Graven Hill Health Hub

Arboricultural Briefing Note

Document Reference: WIE16470-100-BN-10-1-2-2-ABN

An Arboricultural Impact Assessment (AIA) was submitted in April 2021 to support a Full Planning Application for a proposed Health Hub at Graven Hill. The application reference is 21/01454/F and the AIA reference is WIE16470-100-R-10-2-3-AIA.

Project		Graven Hill Health Hub
Title		Illustrative Landscape Plan
Client

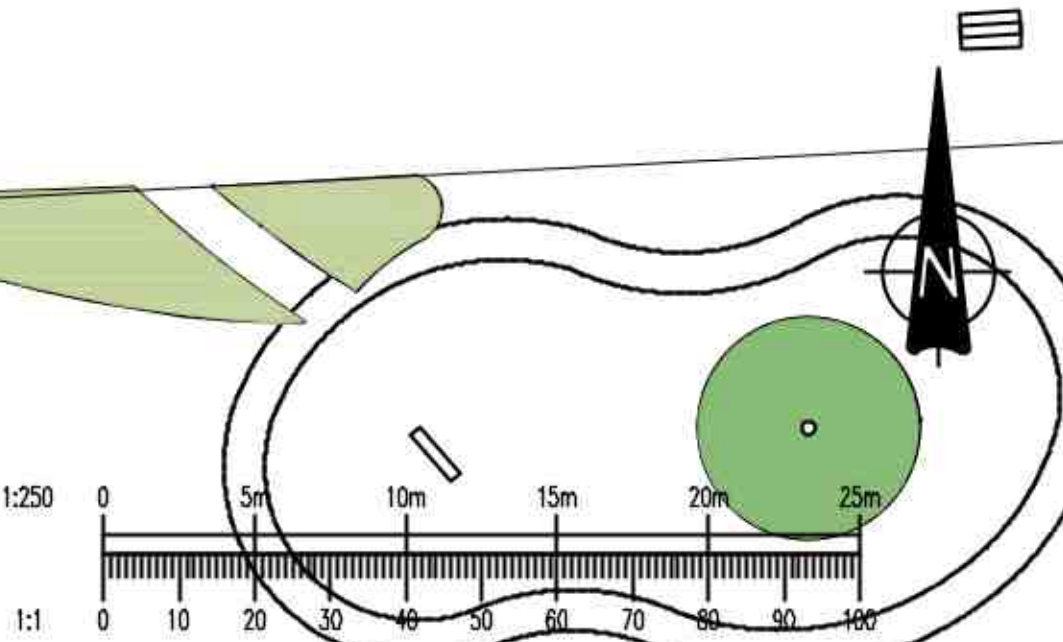
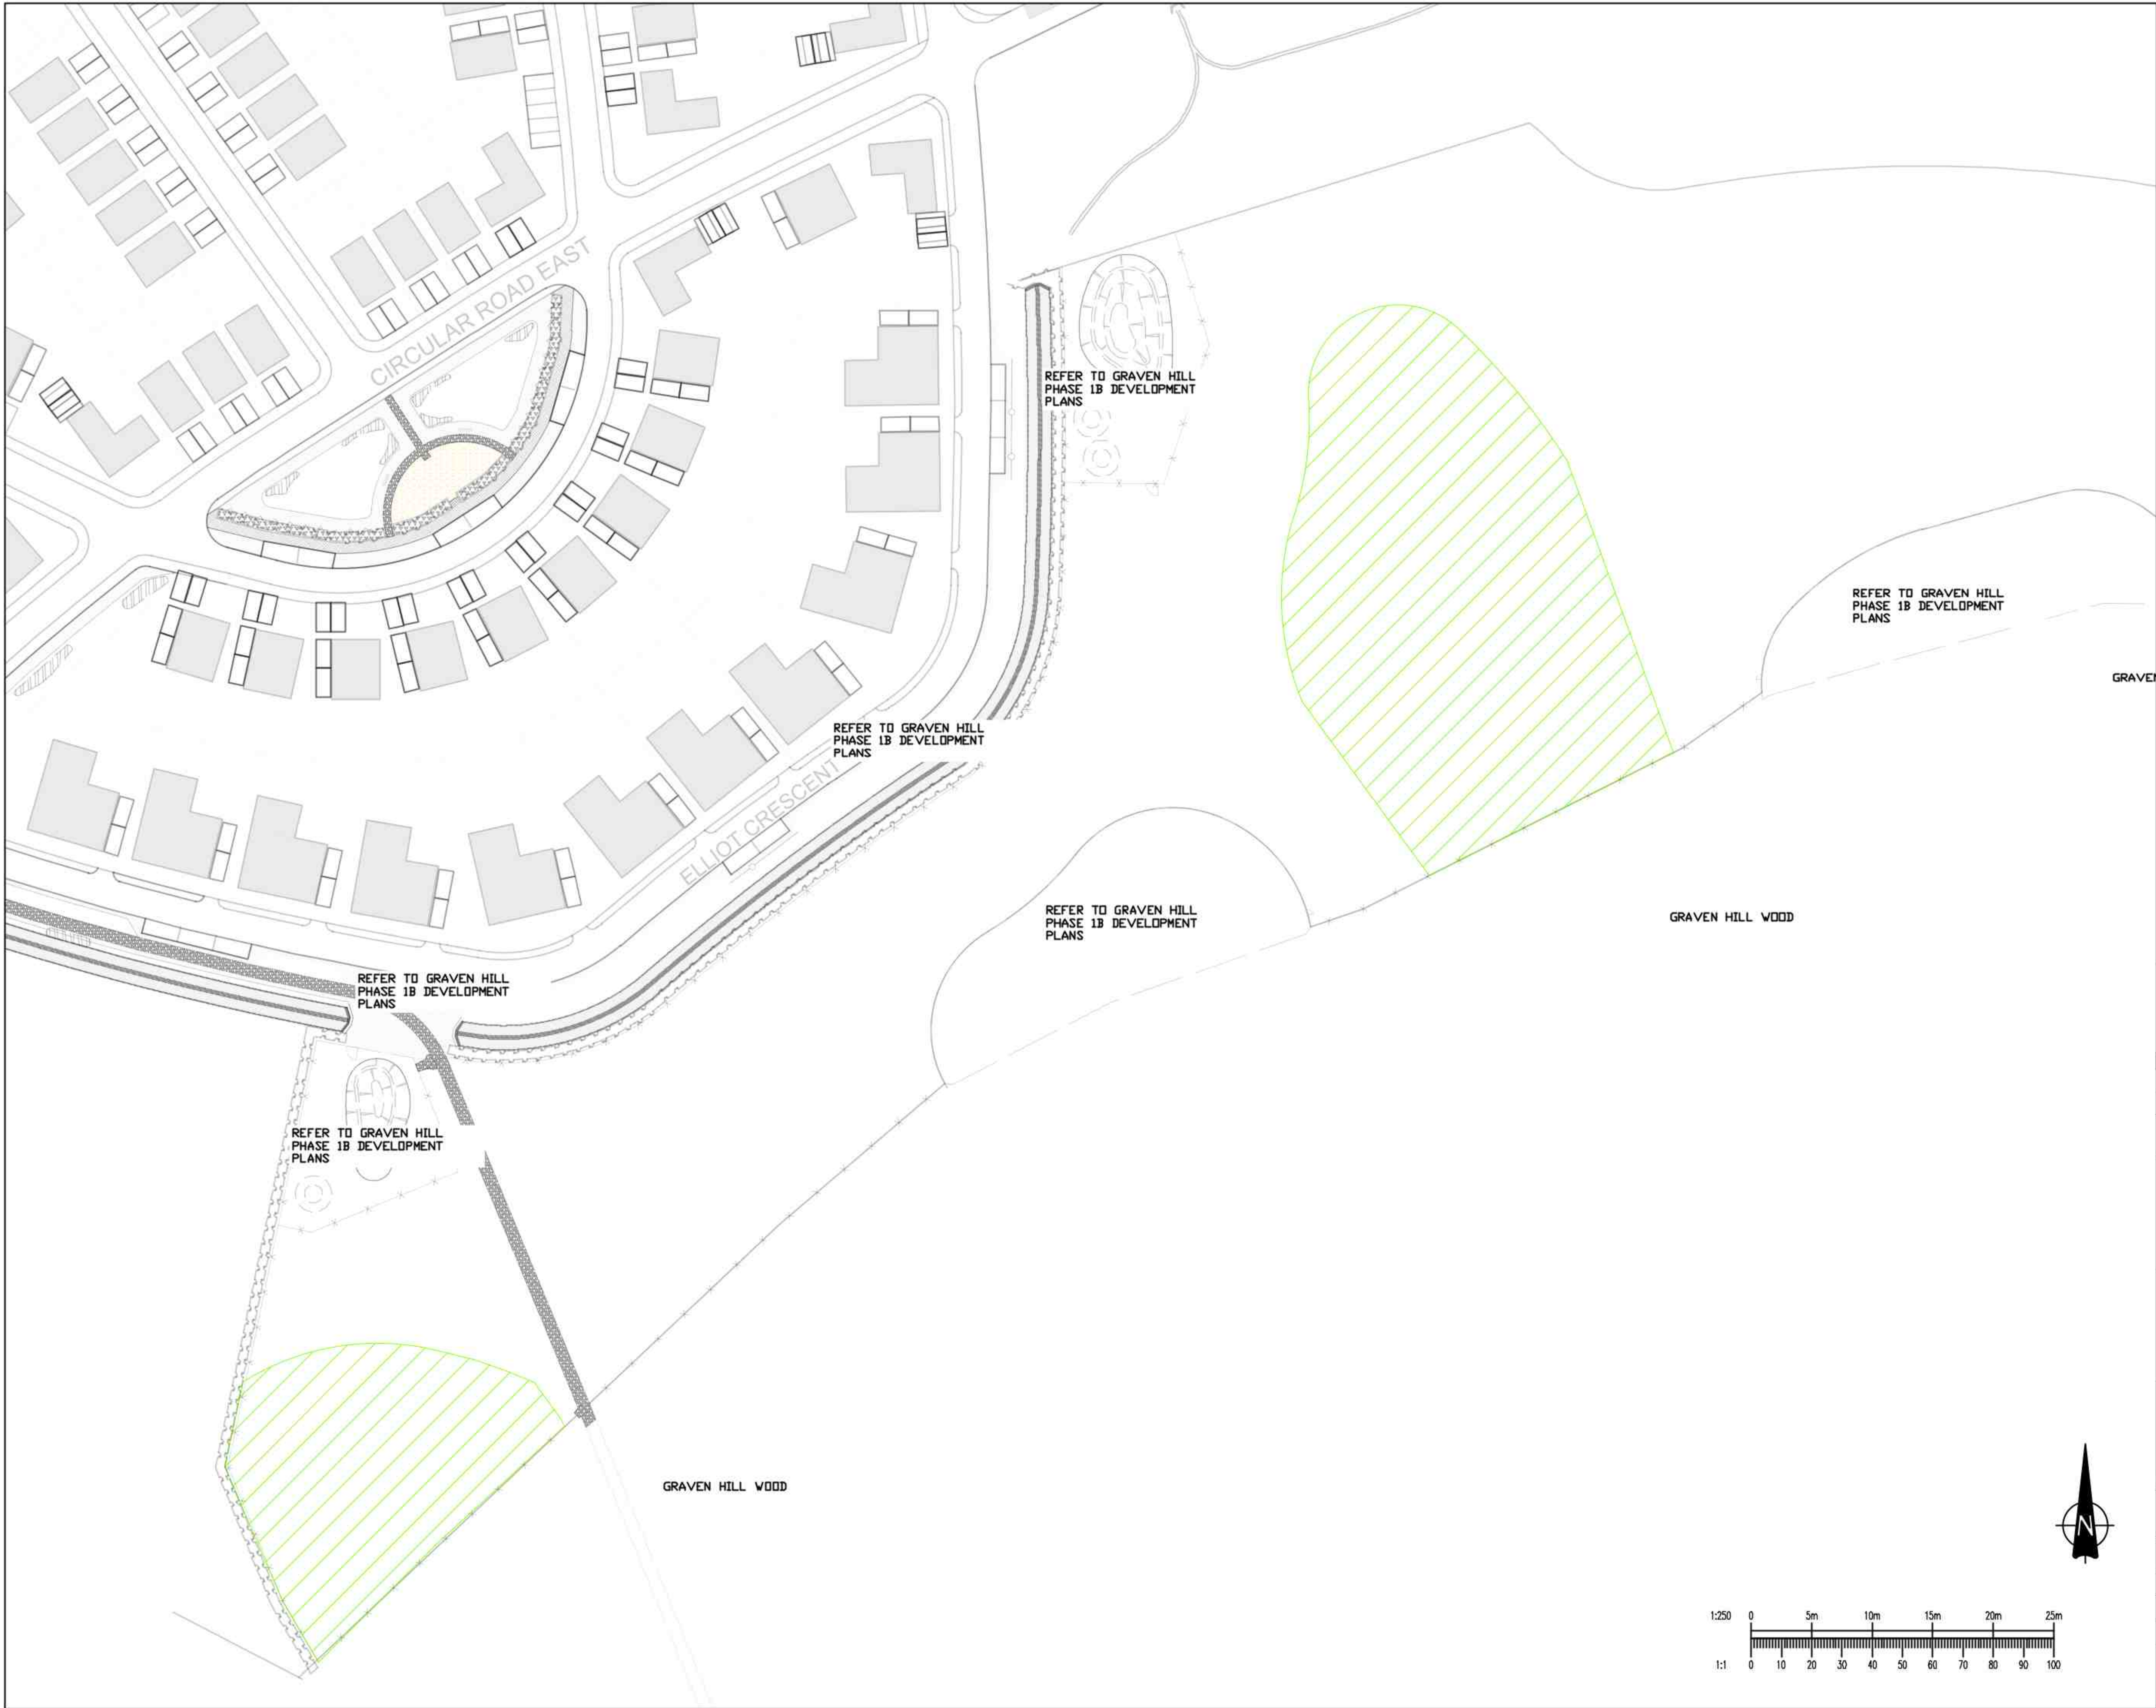
"The proposal requires the removal of 18 trees, retaining only one BS58837:2012 category B tree, and one category B group. On this subject, the submitted Arboricultural report is inconsistent, as table 2, and drawing 3 cites T14 as being removed however, AMS 11.2 and drawing 2 suggest T14 is to be retained. Confirmation is required.

Further to the comments received from CDC in respect to T14, it can be confirmed that T14 is not to be retained on site. Removal of T14 can be seen on the tree removal plan shown in Appendix A of this Briefing Note. It can be confirmed that T13 is to be retained on the site only.
